389 HARLINGTON ROAD, UB8 3JE
Revisions to outline planning application 55857/APP/2017/2608

The scheme that illustrates the development proposed by the above outline planning application has been reconsidered in the light of detailed comments you made on behalf of the local planning authority on the 12th October. Although made late in the day, we have found them very constructive and our client's team, led by Leo Panipucci the project architect, has revised the layout, form and appearance of the building to produce a better scheme and is now, we believe, worthy of the support of the local planning authority.

The development proposed has been changed from six two-bedroom flats on two floors to five two-bedroom flats over three floors. The 'Scheme Overview' overleaf expands on this. The description of development will need to be amended and the planning application put out to further consultation as we have discussed and agreed.

JOB NO: **17107** DWG NO.: **21**

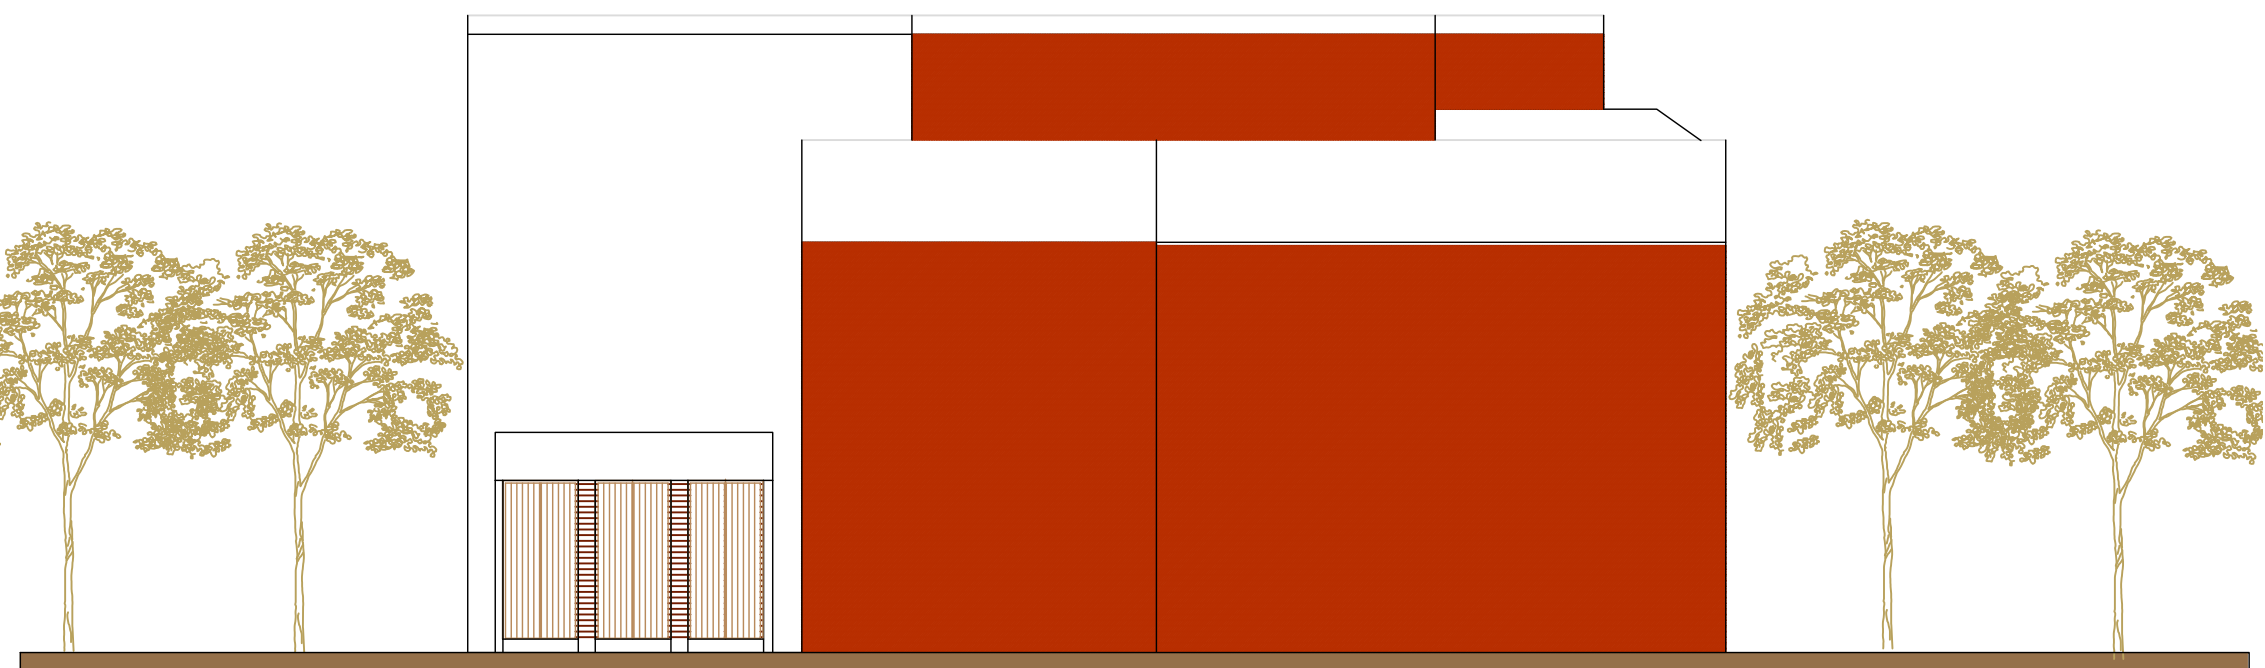
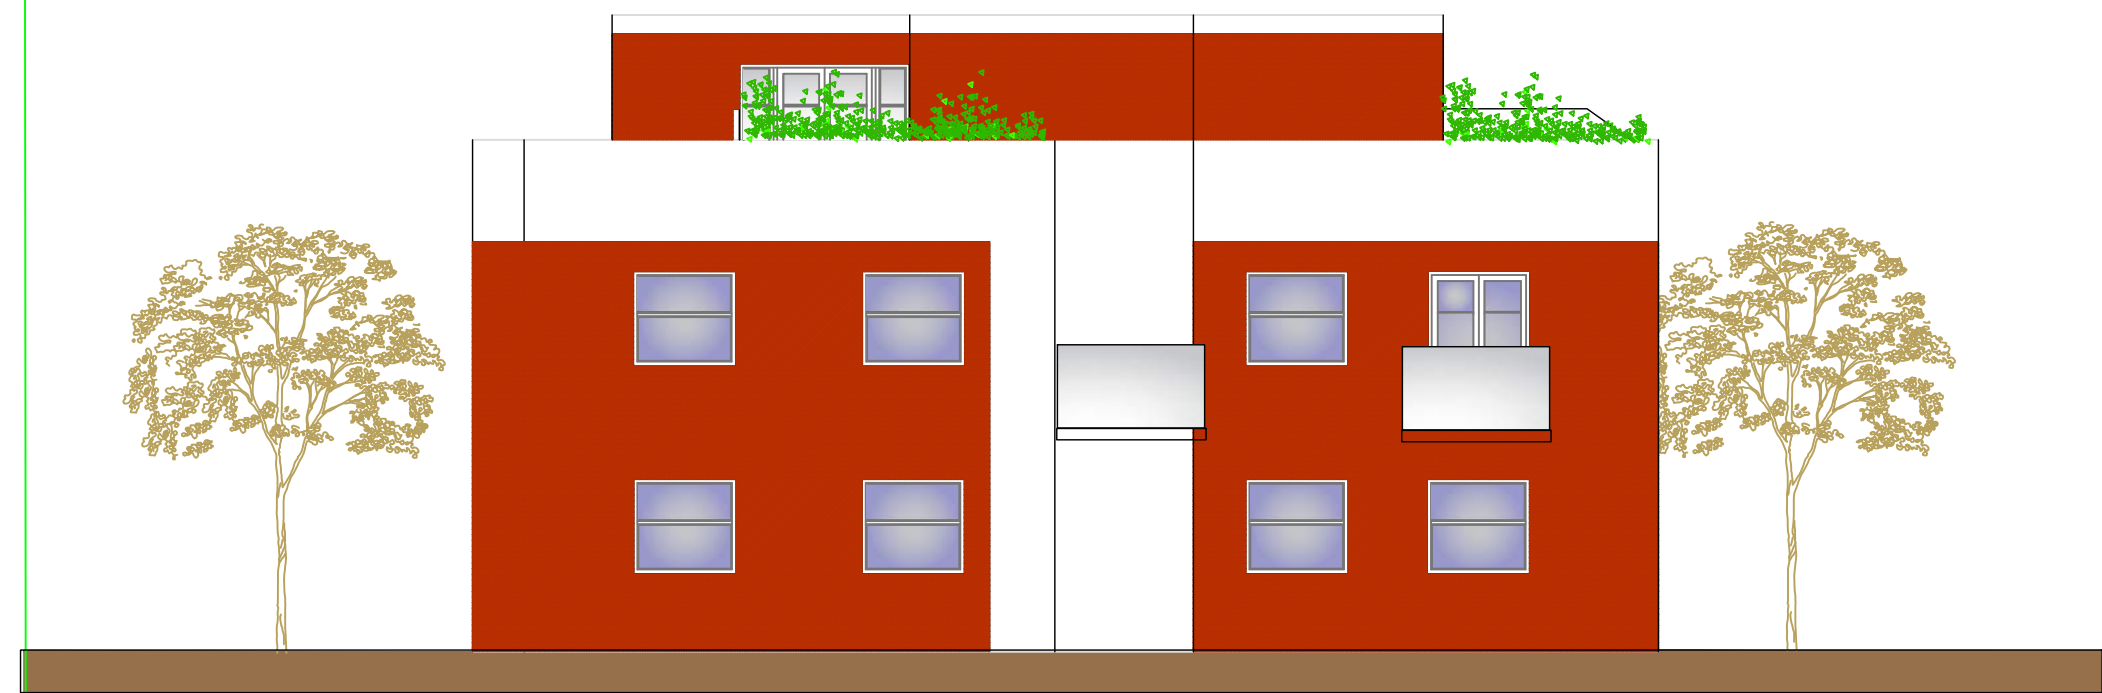
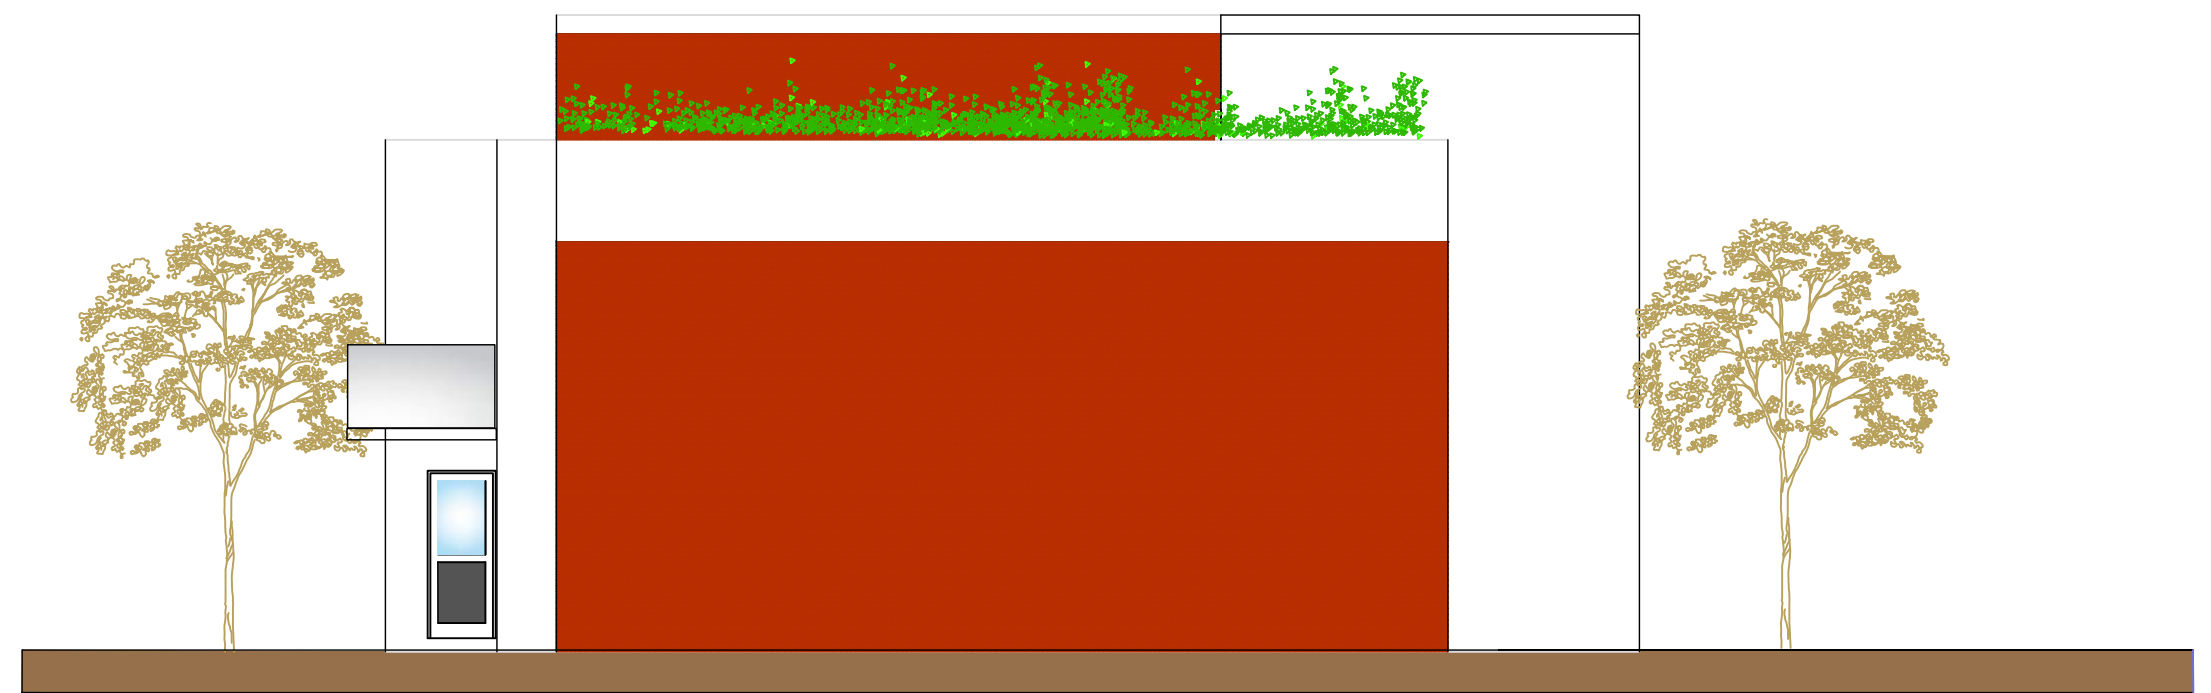
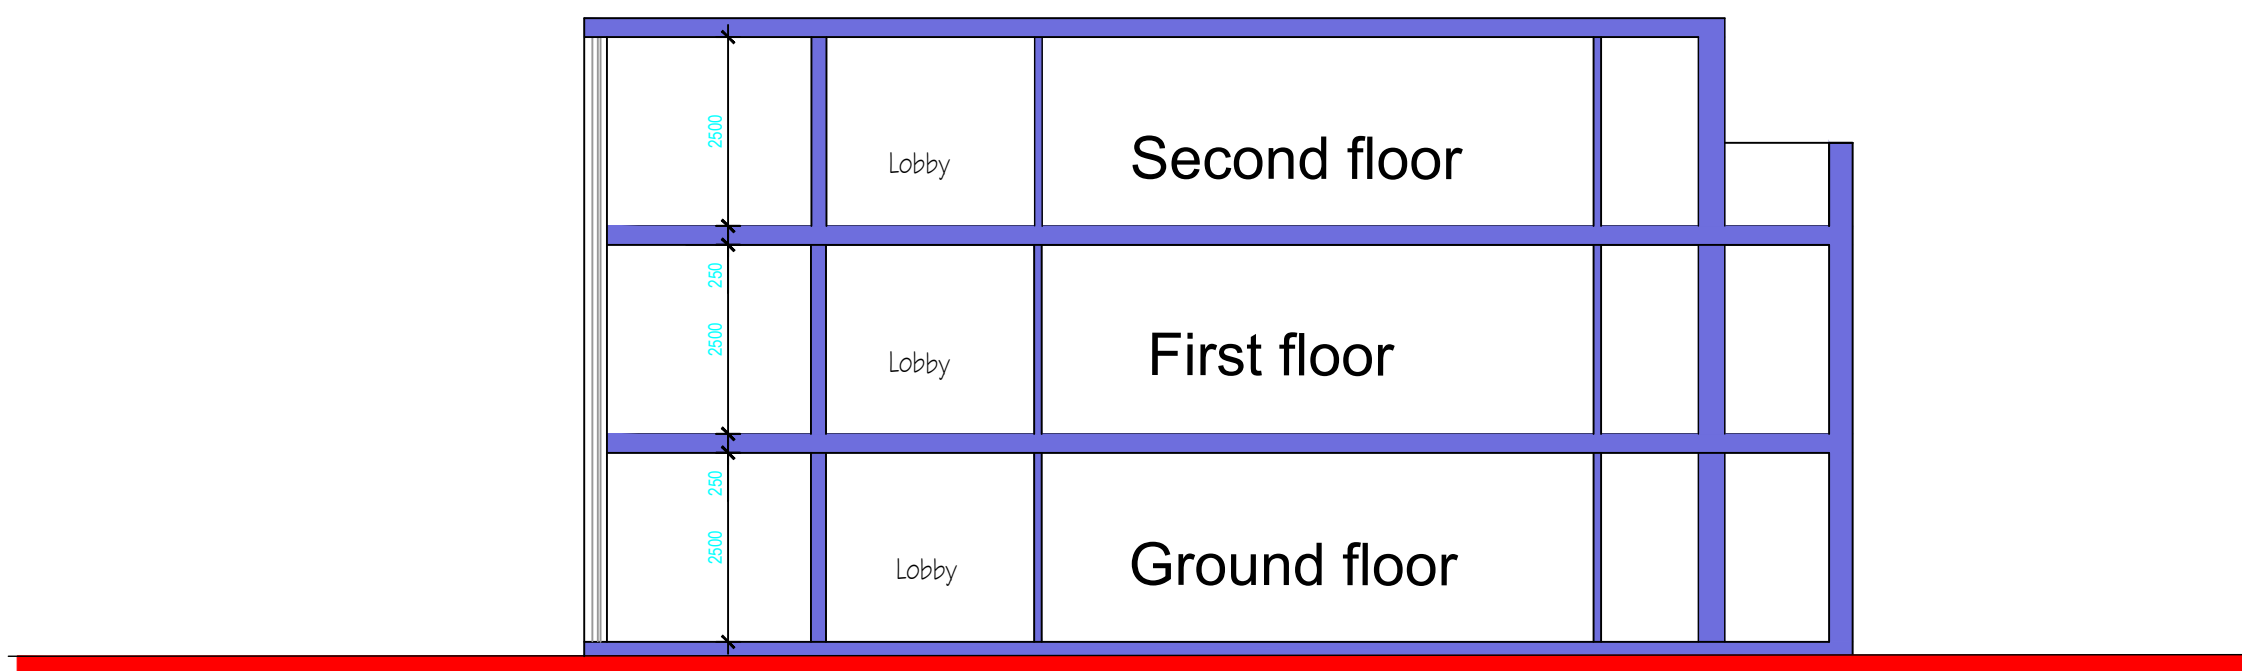
11. The modern design and scale of the scheme would be likely have a detrimental impact on the character and appearance of the street scene.

As shown on the illustrative drawings, the elevations are faced with either brickwork or rendered feature portions. The design will be similar to the nearby 'Five Points' scheme, but we would aim for a superior look and feel.
